**Consultation Response from KC,  
Highways Development Management****2023/93782 14, Firth Street, Huddersfield, HD1 3BA****Erection of extensions and alterations to form 16 student apartments****Date Responded: 17/05/2024****Responding Officer: CNB****Responding Ref: K6-9NE/5**

0 Proposed Ground Floor Plan
 1 : 100

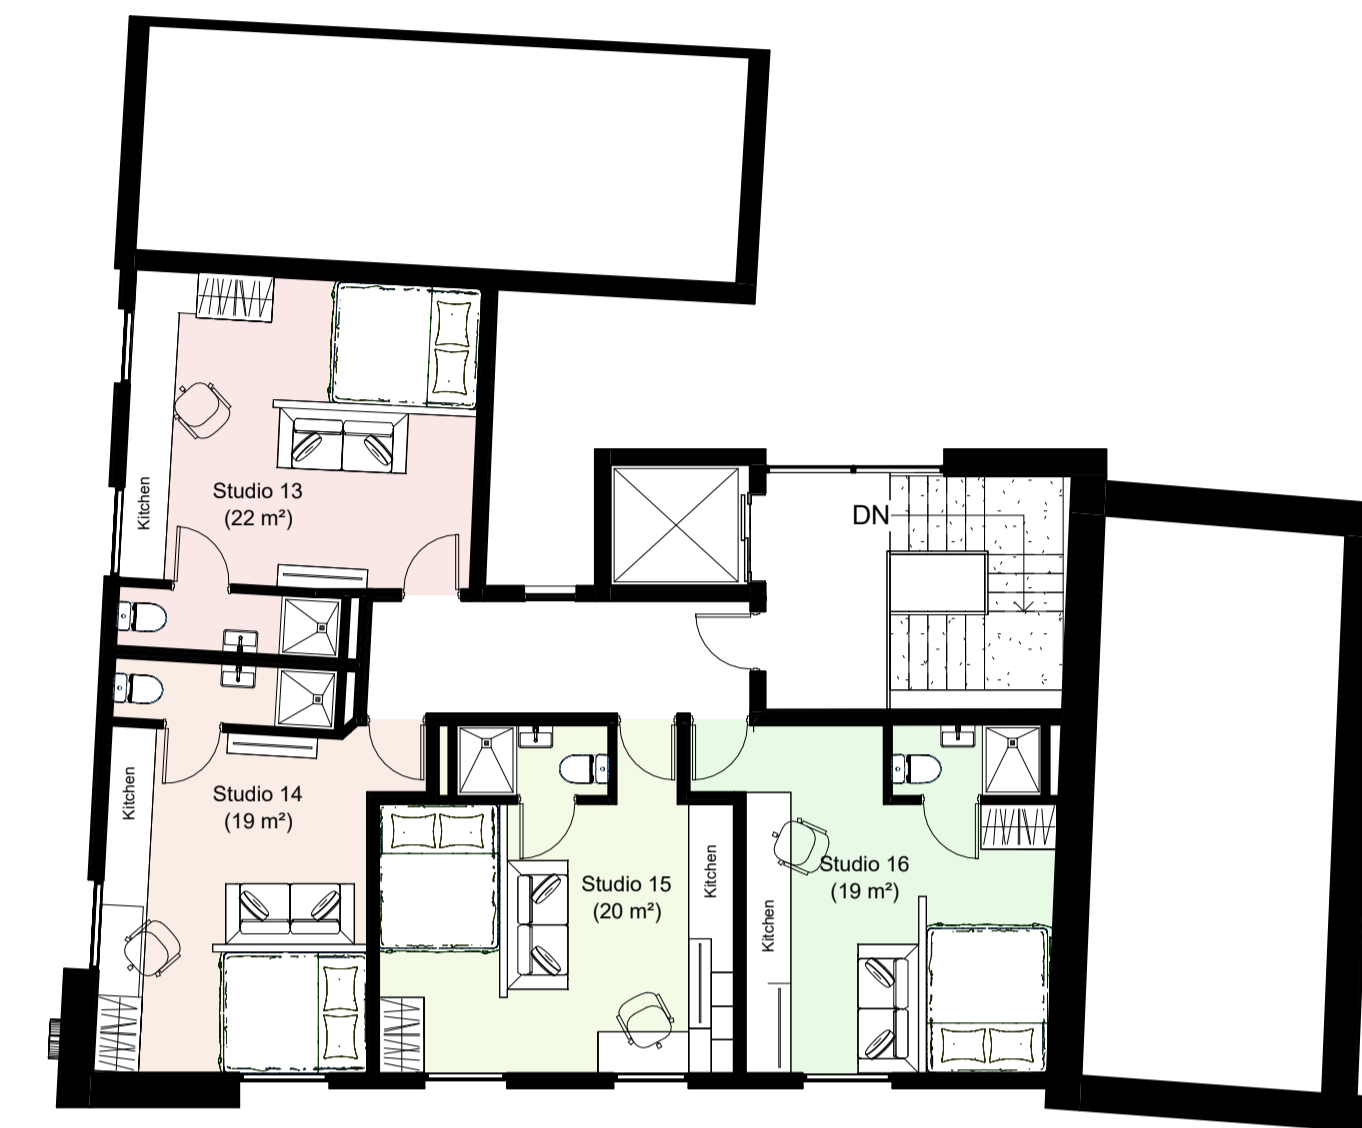
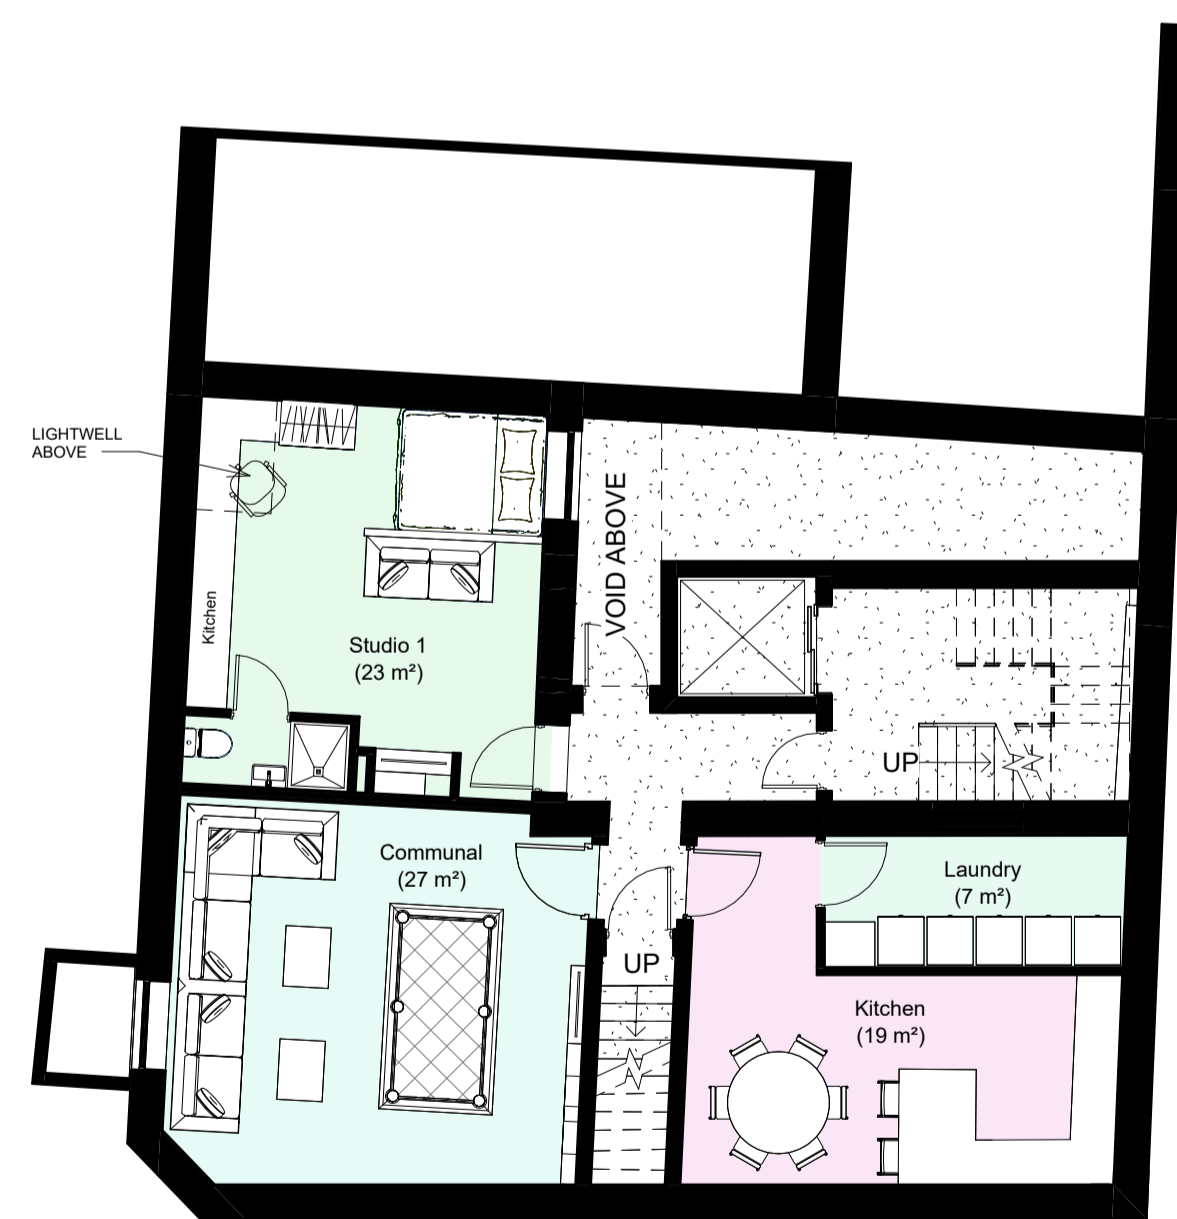
There was no cycle parking provided with the proposals and we feel this is a serious omission, especially when the Design and Access Statement states that "Students living in the proposal will walk and bike as their primary mode of travel" and we would like to see suitable safe and secure cycle storage facilities provided at the site. This should be covered and secure and suitable for 16 cycles (one per dwelling). There appears to be a space on the lower ground floor that may be suitable, although the access would be via steps and so a cycle gutter would be required and the space may be too narrow for standard stands. Provision of residents' cycle storage can be conditioned.

Before development commences, details of suitable cycle storage facilities shall be submitted to and approved in writing by the Local Planning Authority. The approved details shall be provided before first occupation and shall be so retained thereafter.
